16 March 2026

FLOODING PEER REVIEW FOR STATE SIGNIFICANT DEVELOPMENT APPLICATION (SSDA) AT 4-6 POPES ROAD, WOONONA (SSD-73910208), IN RESPECT OF DEPARTMENT OF PLANNING, HOUSING AND INFRASTRUCTURE RFI DATED 25 FEBRUARY 2026

Table 1 MA peer review of DPHI comments and ACOR responses.

FIGURE F52

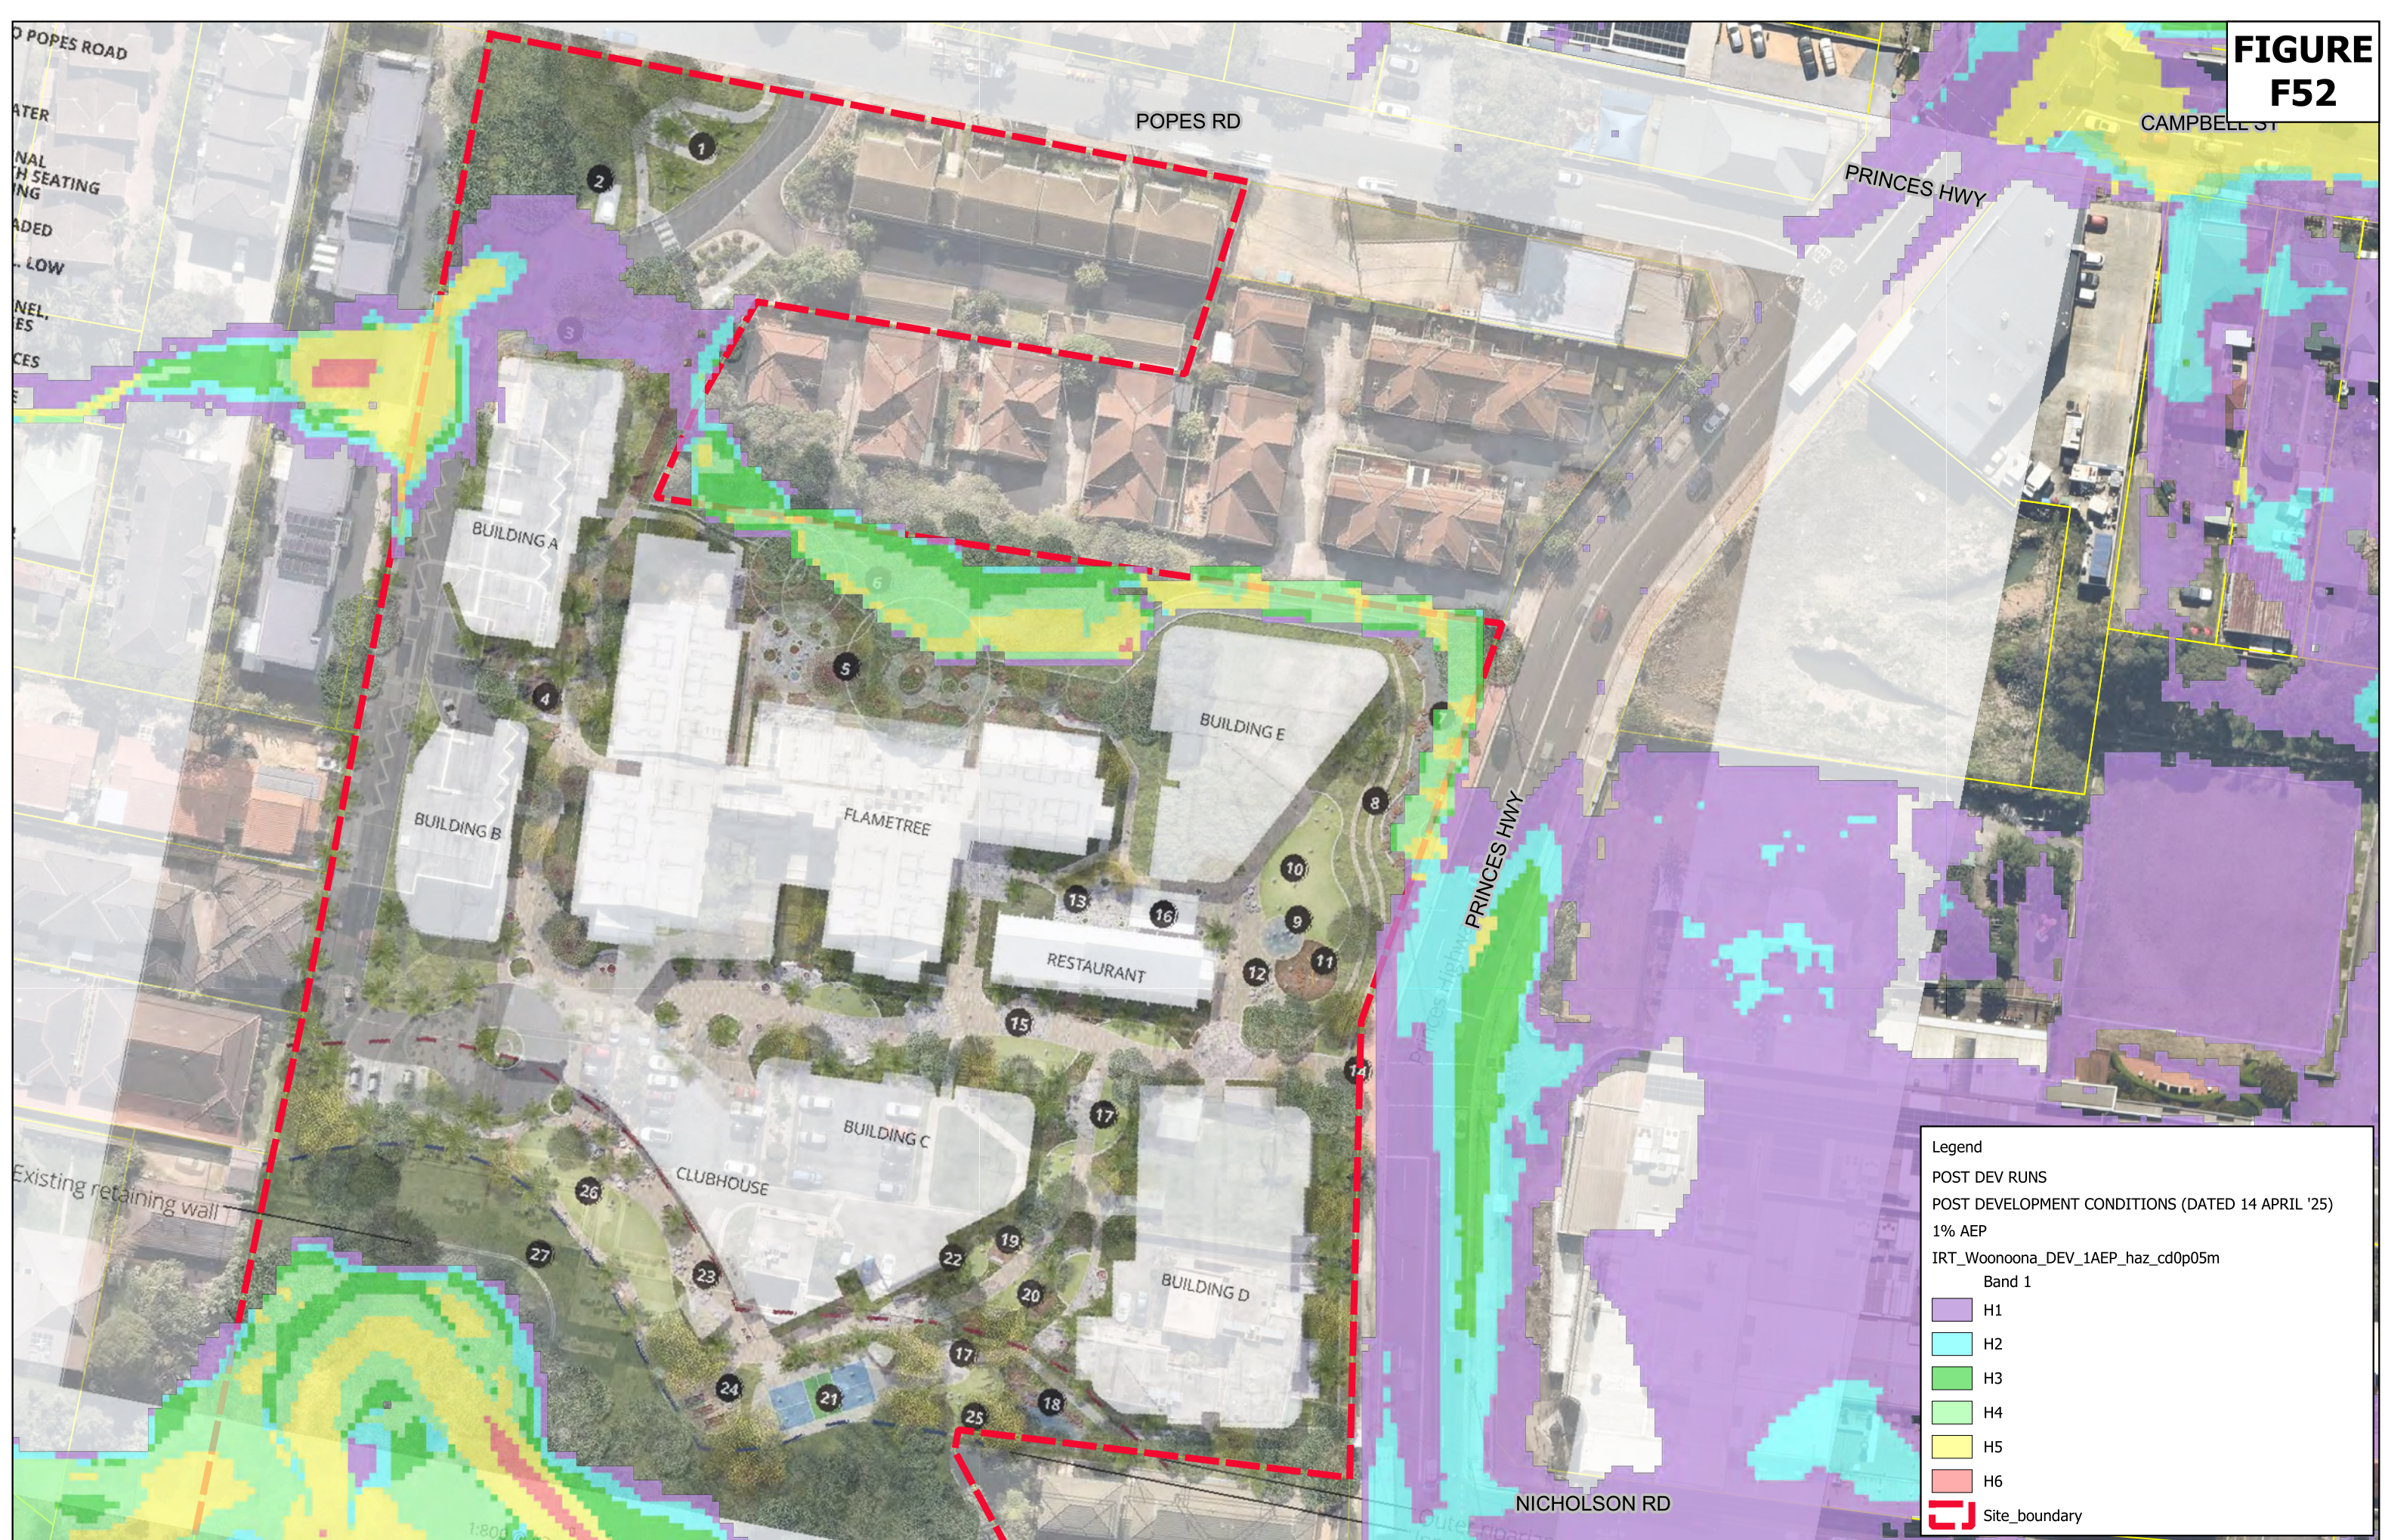
a. the 1% AEP post development map (Figures 50 to 52) extent is to be updated to show the entire site	a. The 1% AEP post development map (Figures 50 to 52) have been updated to include the entire site. See attached.	No further comment.

# Detail Area Drainage Channel

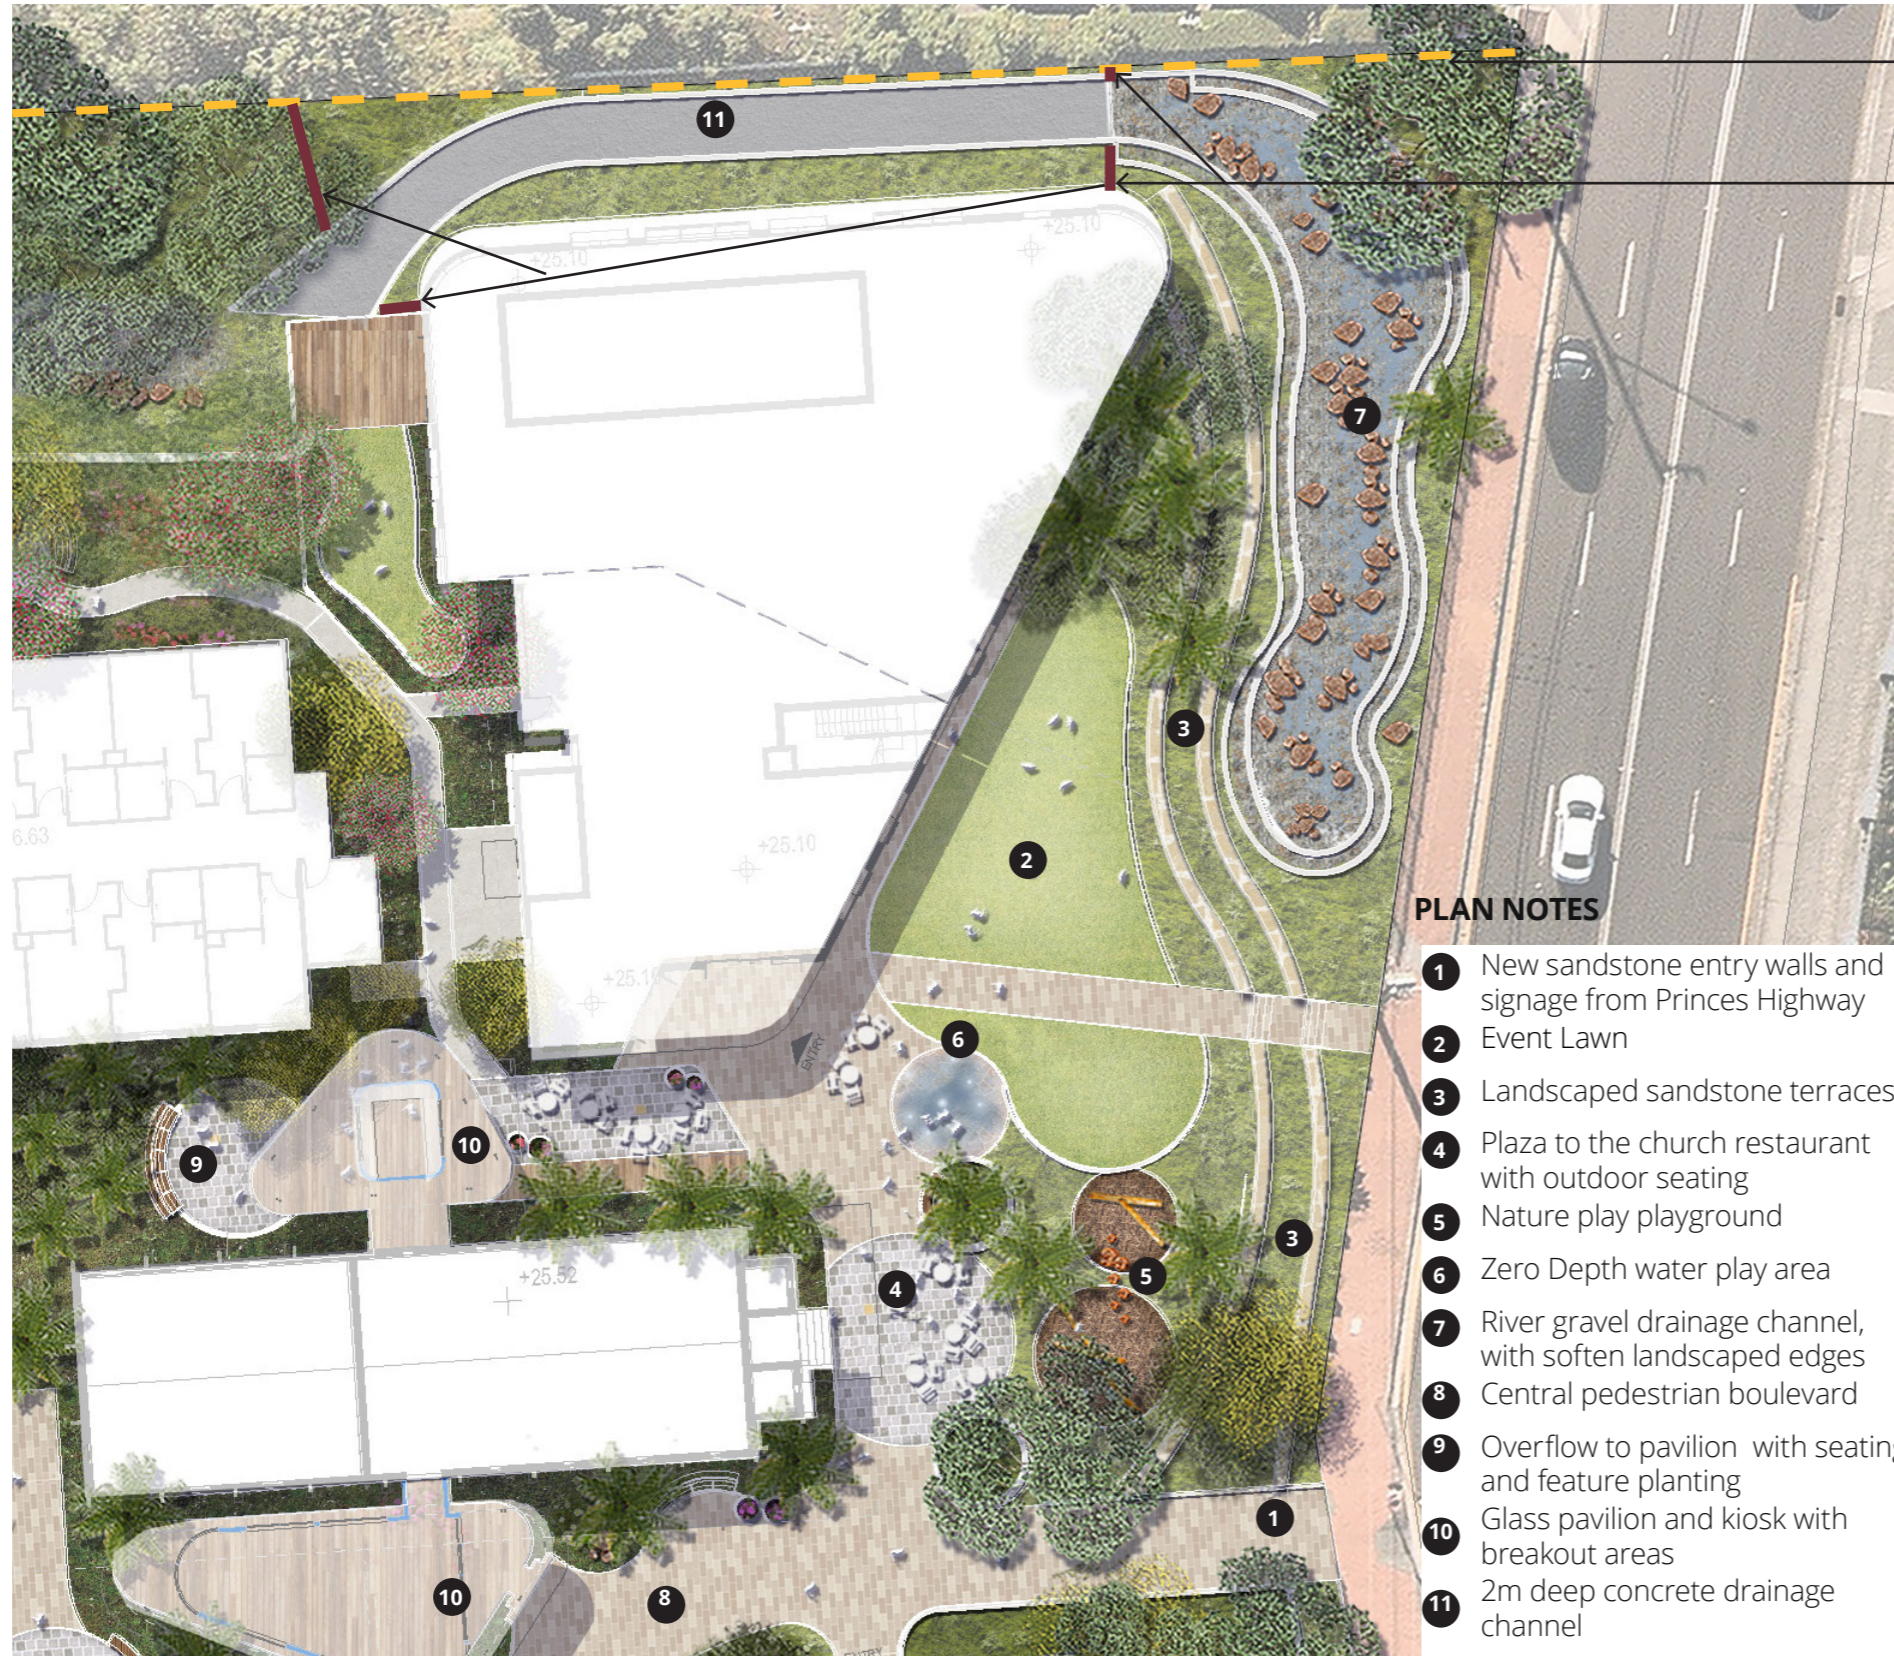
2. Diversion of stormwater flow to the north of Building E. While the Department notes that the proposed stormwater culvert is necessary to divert stormwater	2. Diversion of stormwater flow to the north of Building E Response: The Department's suggestion to replace the culvert (in actual fact a	We understand that the proposed northern channel is to be fully enclosed with a grassed swale provided above (refer to Innovis SW Memo).

DPHI RFI	ACOR Response	MA Peer Review
around Building E, the Department is concerned with the poor landscape quality, visual appearance and safety of the culvert dominating the northern part of the site which is highly visible from surrounding residences and the Princess Highway. The Department therefore requires design changes (which could take place via condition, if approved) for this culvert to be replaced with 1.2m pipe, with a slight swale feature above with gentle side batters (at 1:4 to facilitate mowing). The Department considers that this change will improve landscape quality, visual appearance and safety.	concrete open channel) with a 1.2 m pipe will be replaced with a reinforced concrete box culvert (RCBC). The roof of the culvert will be topsoiled and grassed (with a potential slight swale feature). This can be investigated and will require flood model simulations to confirm size of the box culvert. It is agreed that this can be conditioned.
